Application for a non-material amendment following a grant of planning permission.

Unit:		House number:	196	House suffix:	
House name:					
Address 1:	SEA WAY				
Address 2:	ELMER SANDS				
Address 3:	ELMER				
Town:					
County:	WEST SUSSEX				
Postcode (optional):	PO22 6JY				
Description of location or a grid reference. (must be completed if postcode is not known):					
Easting:		Northing:			
Description:

2 STOREY EXTENSION TO PROVIDE ENLARGED BEDROOM,
EN SUITE, BATHROOM, GUEST ROOM, HALL + ENLARGED
KITCHEN

HOUSEHOLDER PLANNING APPLICATION, TO CHANGE THE 2 STOREY
FRONT EXTENSION TO A SINGLE STOREY FRONT EXTENSION,
WITH A FLAT ROOF.
ALSO TO MAKE EXTERNAL LENGTH OF EXTENSION ^{3.2} ~~2.9~~ m INSTEAD
OF 2.9 m.
TO PUT OBSCURE SMALL WINDOW IN ABOVE TOILET IN NEW
SHOWER ROOM. TO KEEP ACCESS TO SHOWER ROOM FROM HALL-
WAY.

GROUND FLOOR PLAN

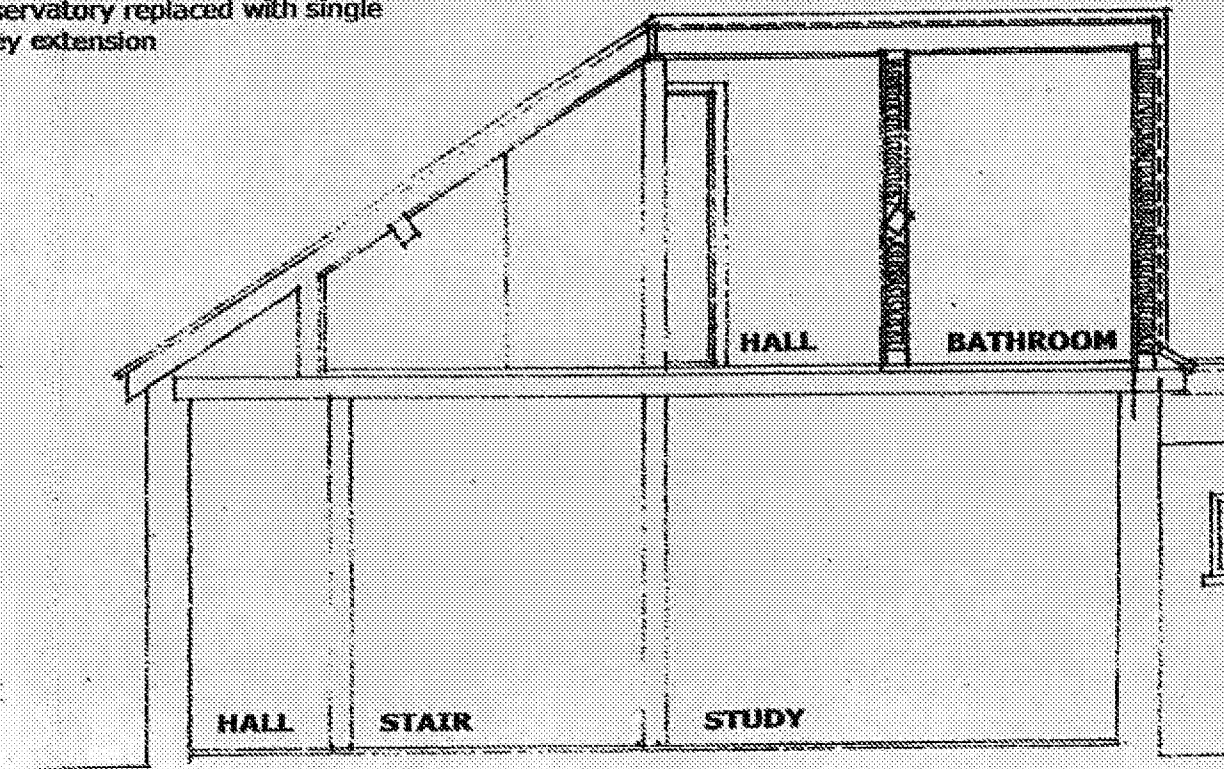
TO SHOW THE FLAT ROOF WHERE POSSIBLE + SLIGHT
INCREASE IN LENGTH OF EXTENSION.
TO SHOW NEW WINDOW IN SHOWER ROOM + CHANGE OF
DOOR POSITION. (HIGHLIGHTED IN YELLOW)
